Project: **134-140 MARSDEN STREET,  
PARRAMATTA (V BY CROWN)**

Report: **BCA ASSESSMENT REPORT**

Document: **103823-BCA-r2**

Date: 10<sup>th</sup> September 2012

Drawing Title
BASEMENT 1

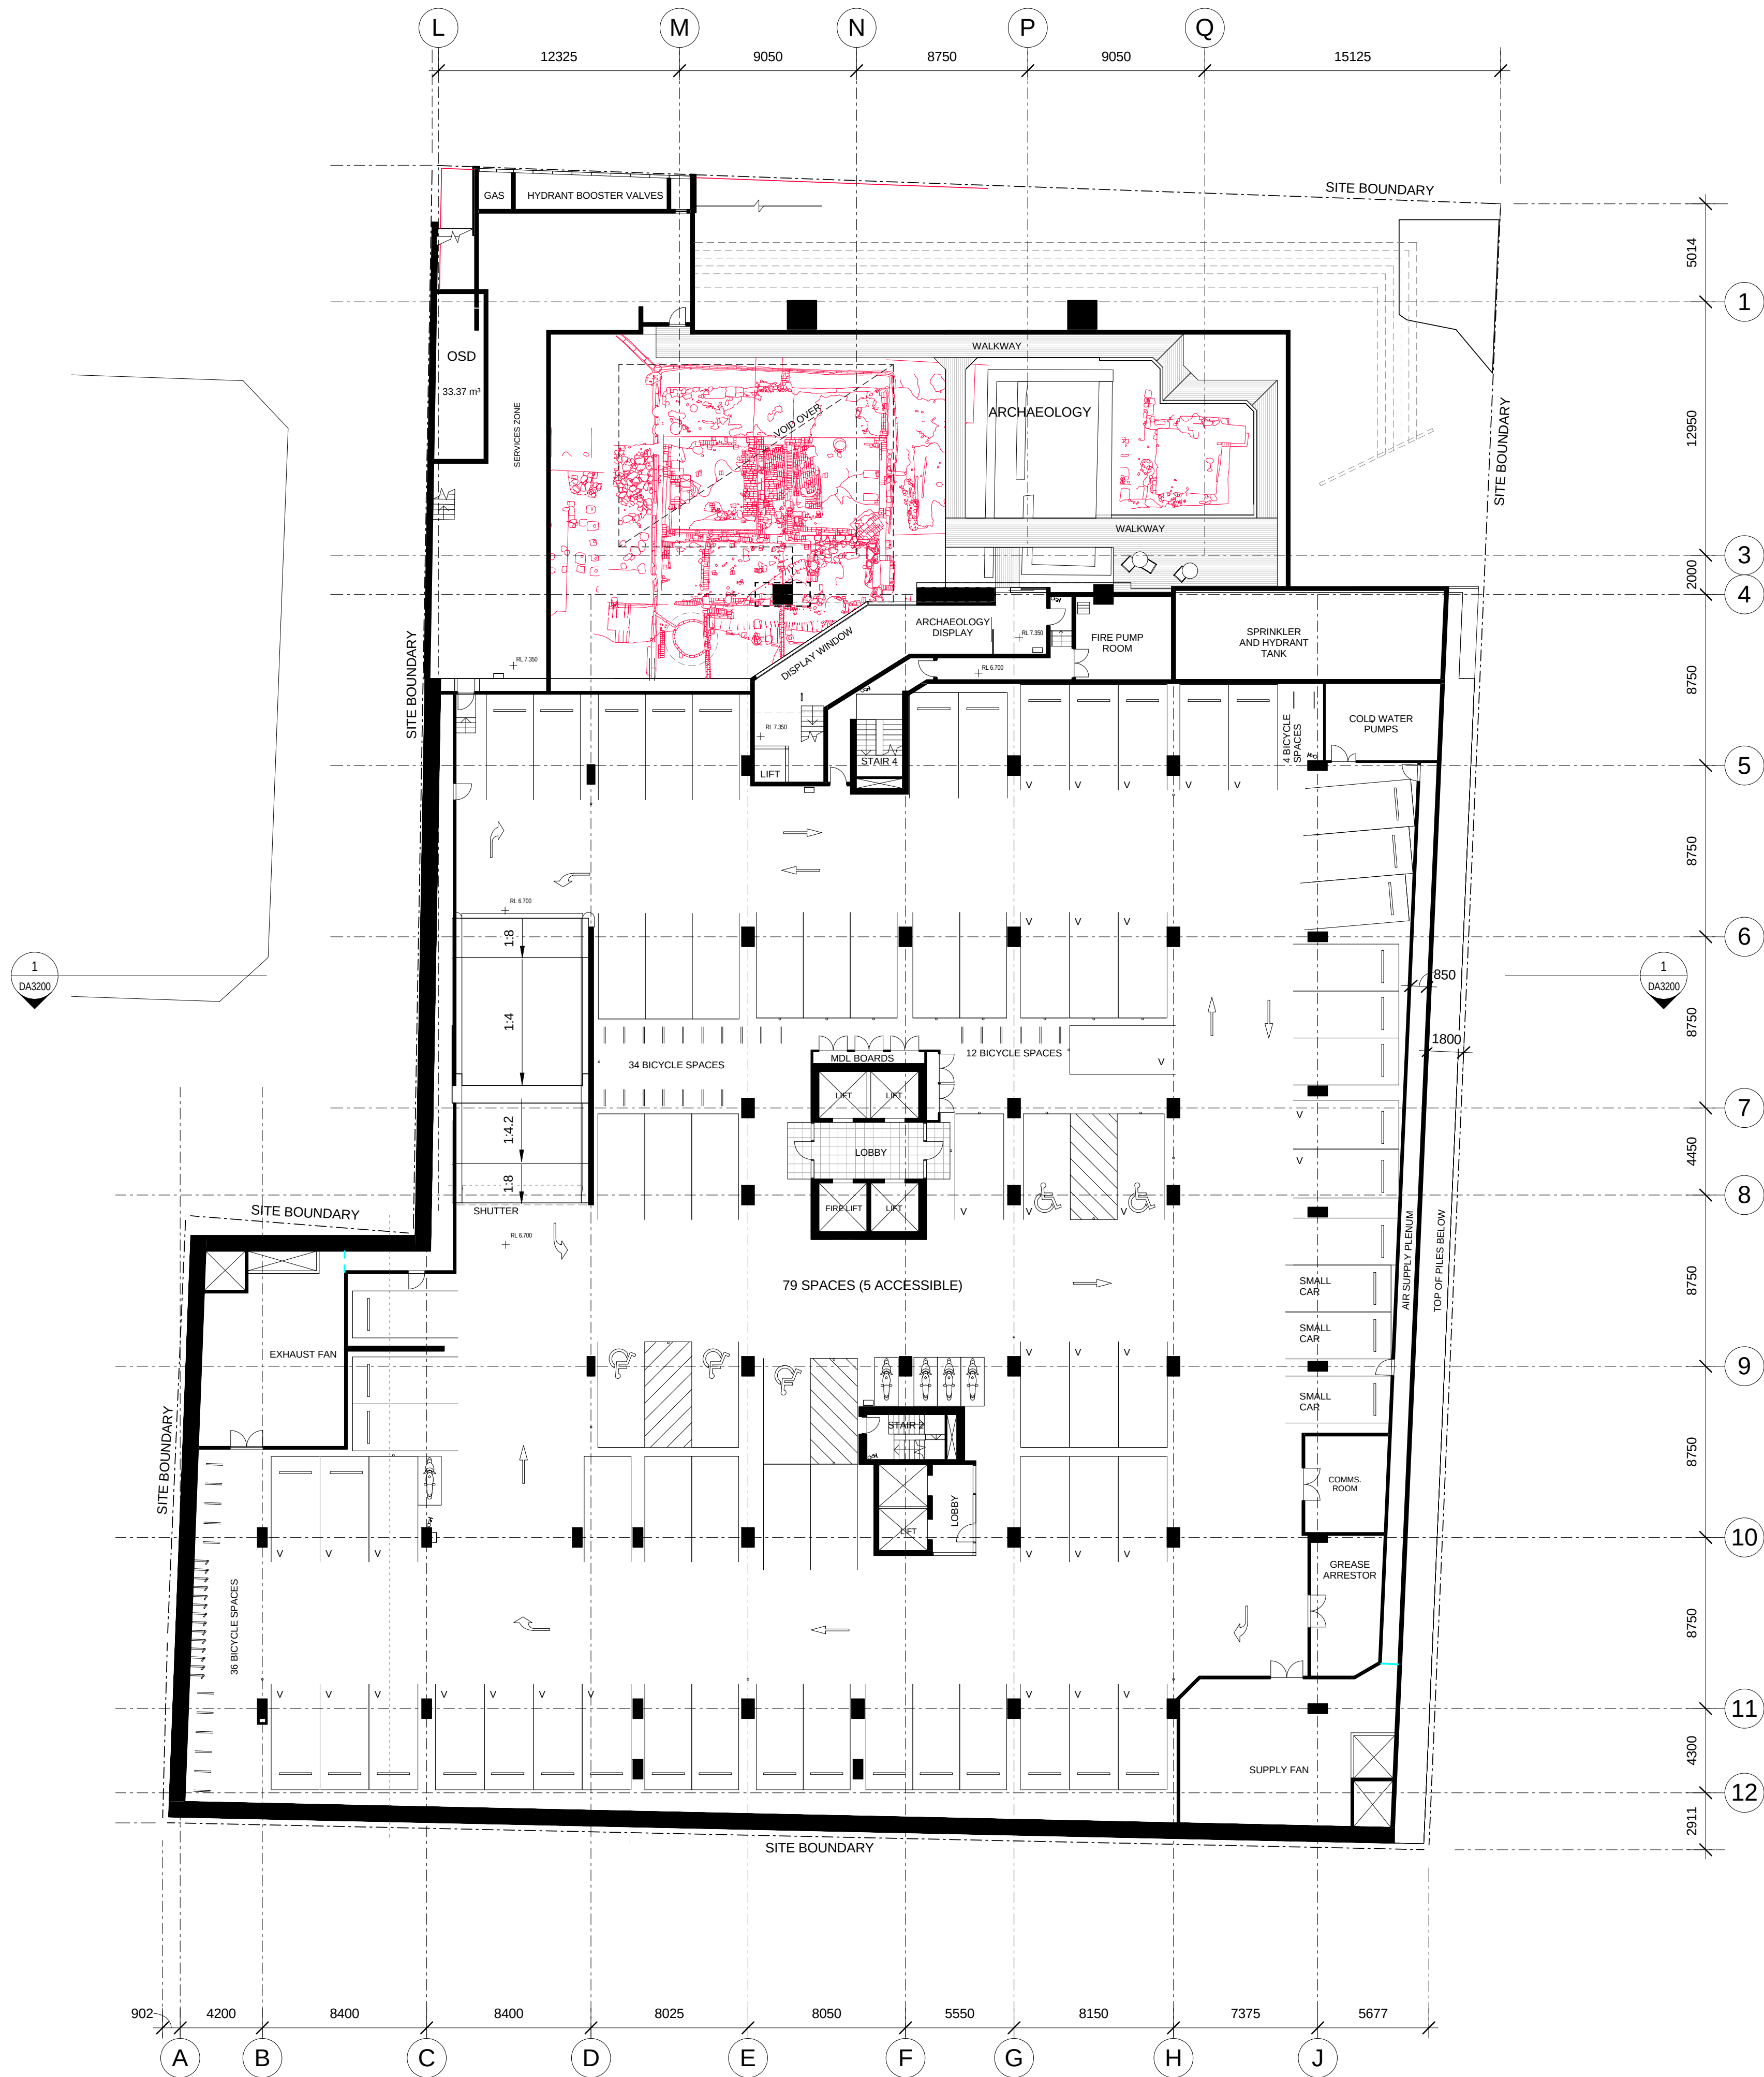
3.	The width of plenums associated with the basement carpark levels are 850mm wide in lieu of the minimum 1m.	D1.6 (b) of BCA 2012	DP4
4.	Fire-isolated stairways 1 and 4 at the northern end of the building discharge within the building.	D1.7(b) of BCA 2012	DP4

Drawing Title
MEZZANINE

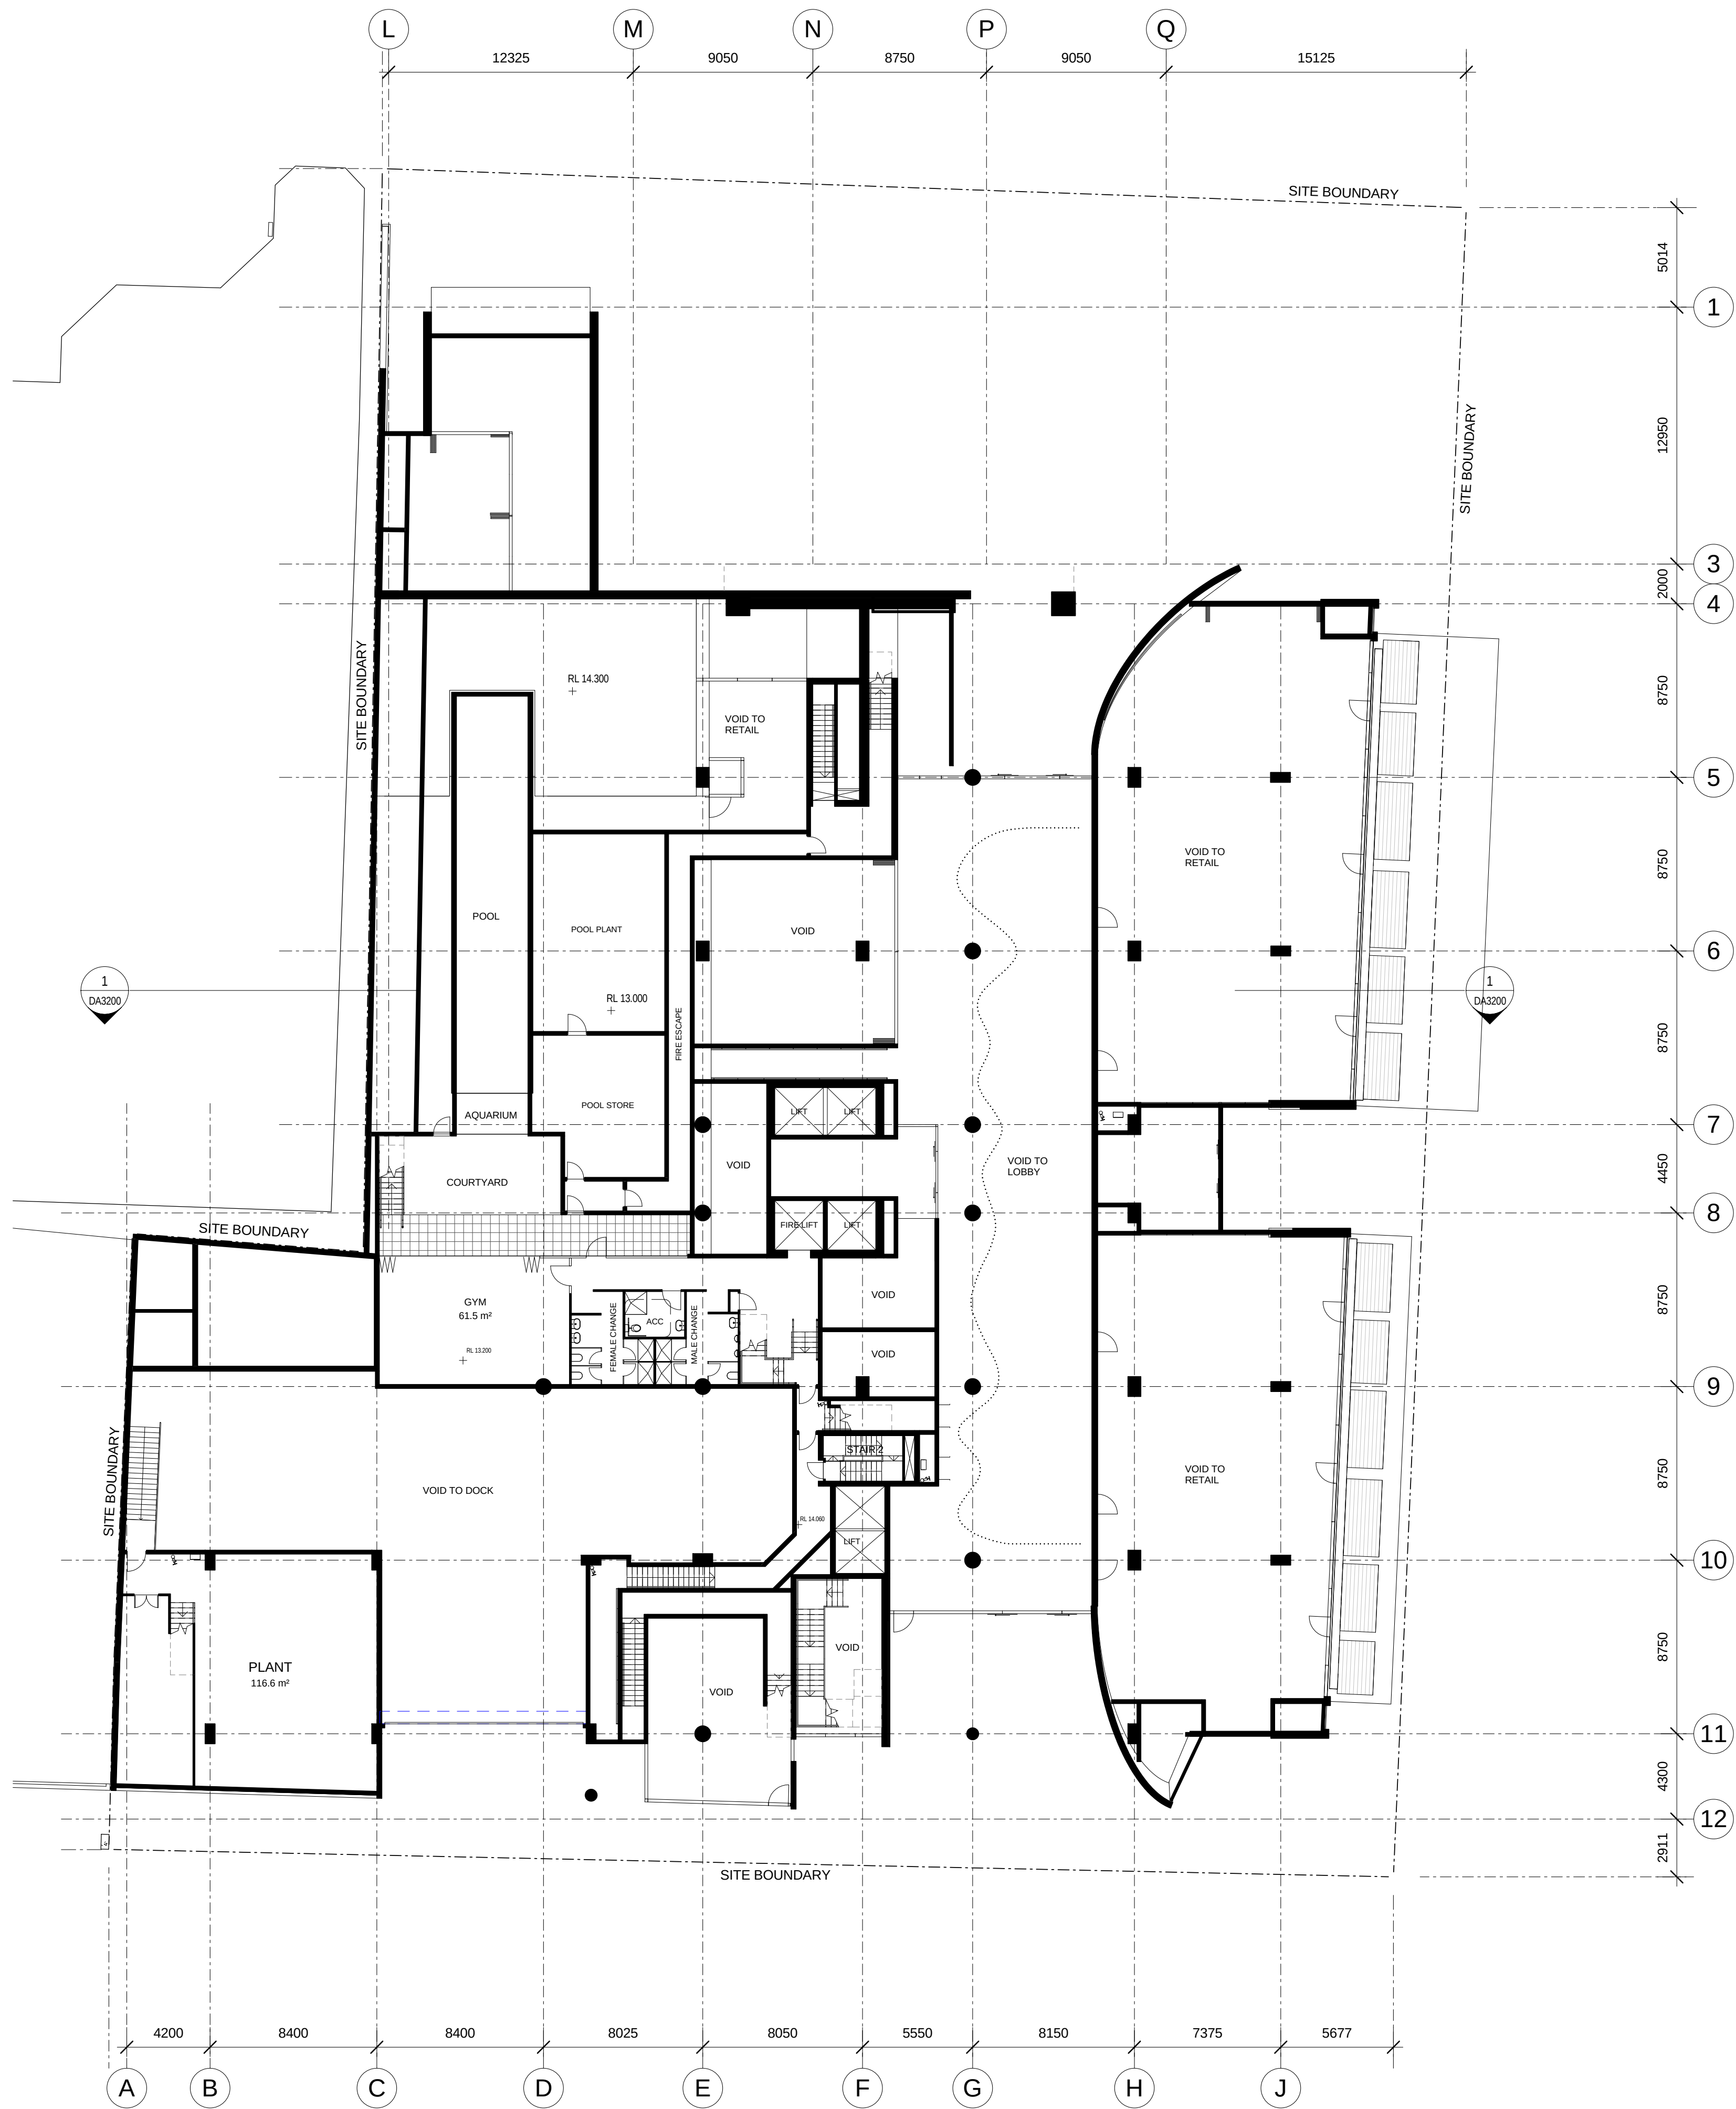
5.	Travel via the non-fire-isolated stairways from the plant room on the mezzanine level to the point of egress exceeds 80m.	D1.9 (c) of BCA 2012	DP4
6.	The fire hydrant booster valve is located in a position that is not protected by walls achieving an FRL of 90/90/90 extending 3m above and 2m either side of the booster assembly in accordance with AS 2419.1.	E1.3 of BCA2012	EP1.3
